DEADLINE 10 SUBMISSION

**GORSAF BWER NIWCLEAR ARFAETHEDIG WYLFA NEWYDD / PROPOSED WYLFA
NEWYDD NUCLEAR POWER STATION**

RE: NATURAL RESOURCES WALES' DEADLINE 10 SUBMISSION

Appendix 1-1 WNDA Operation

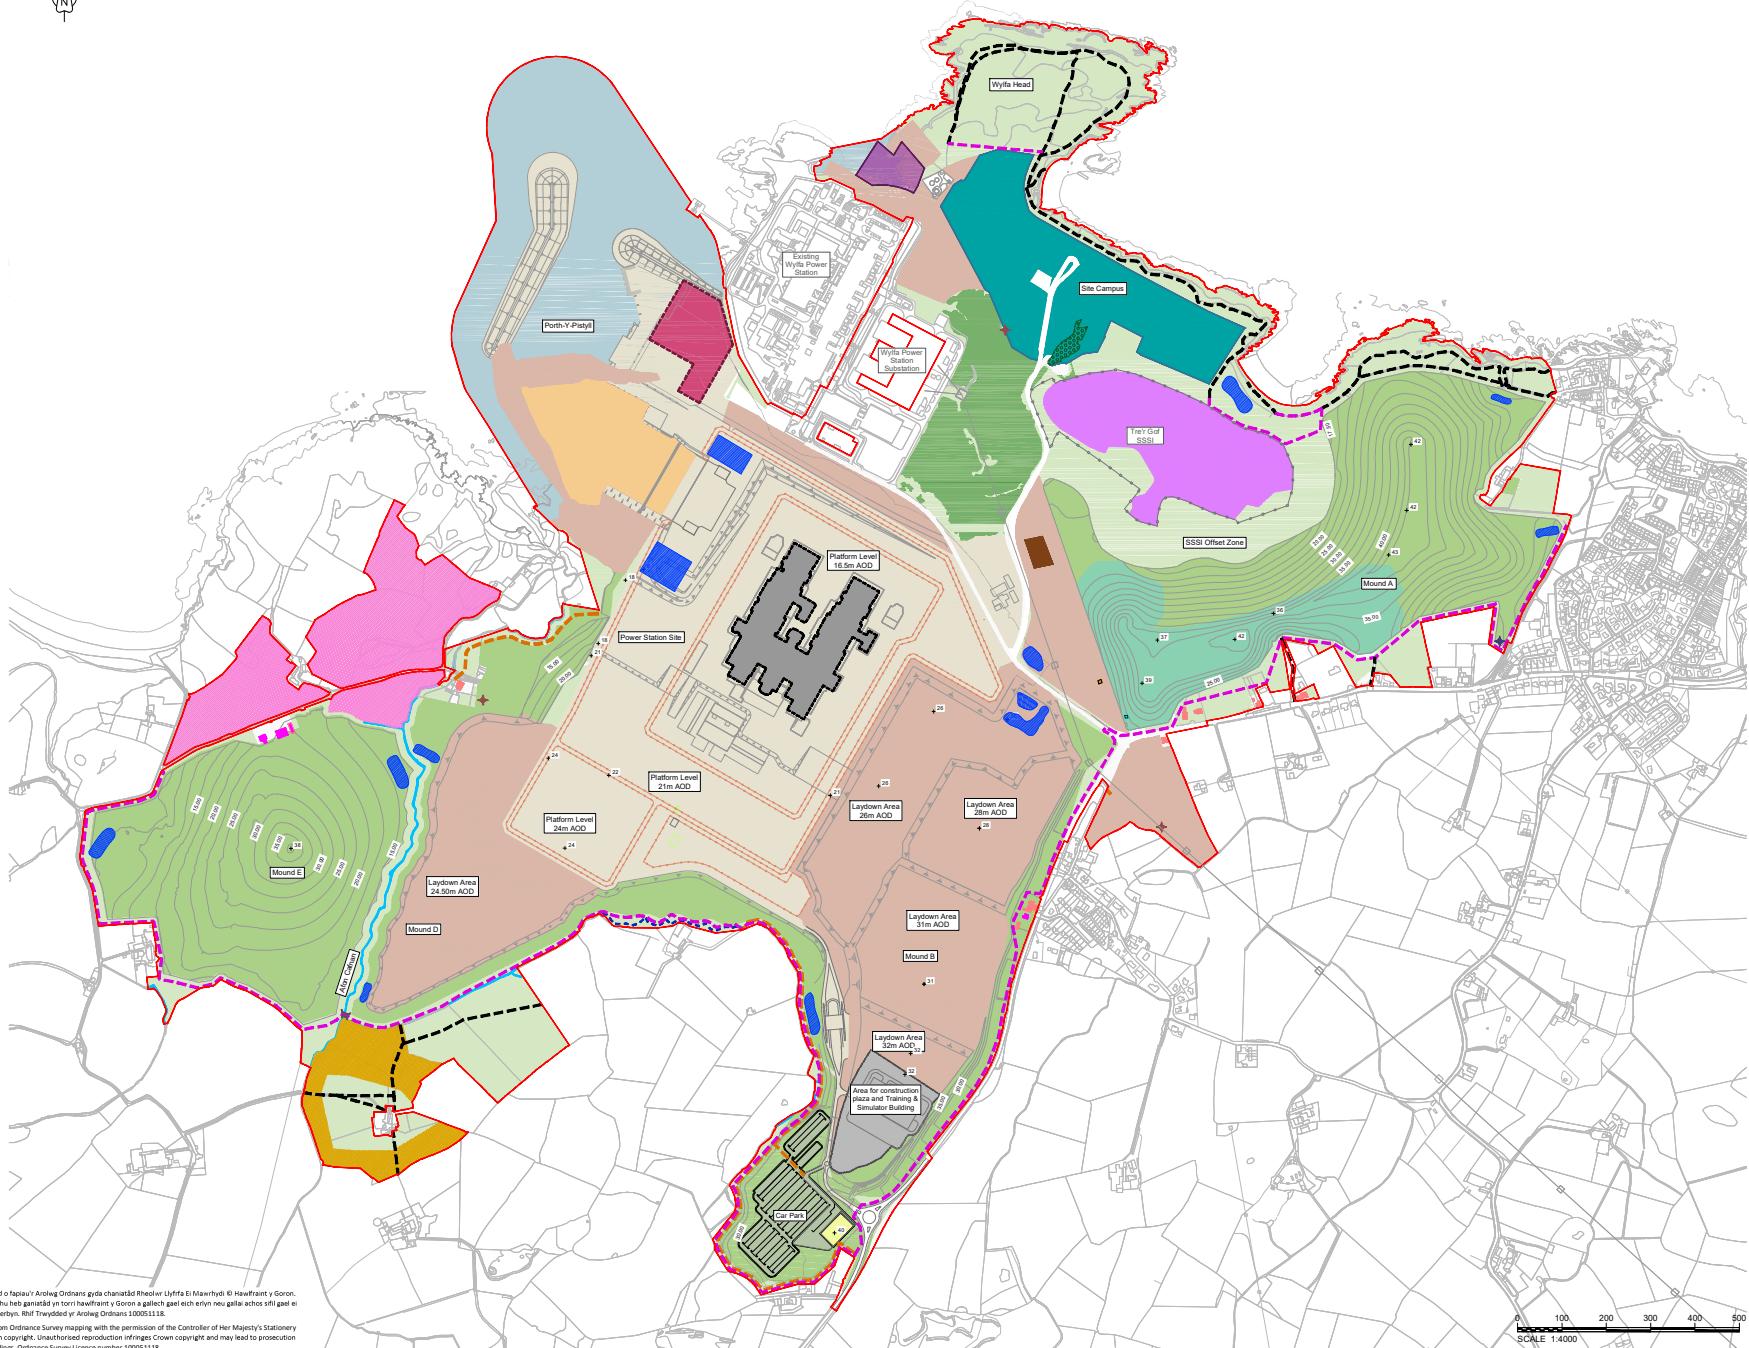
(6) Sub paragraph (1) shall not apply to Work No 3 or Work No 12 (except no works may be commenced on land to the west of Afon Cafnan as identified on [Drawing WN0903-JAC-OS-DRG-00034] (Appendix 1-1) during the tern breeding period, unless otherwise agreed with IACC).
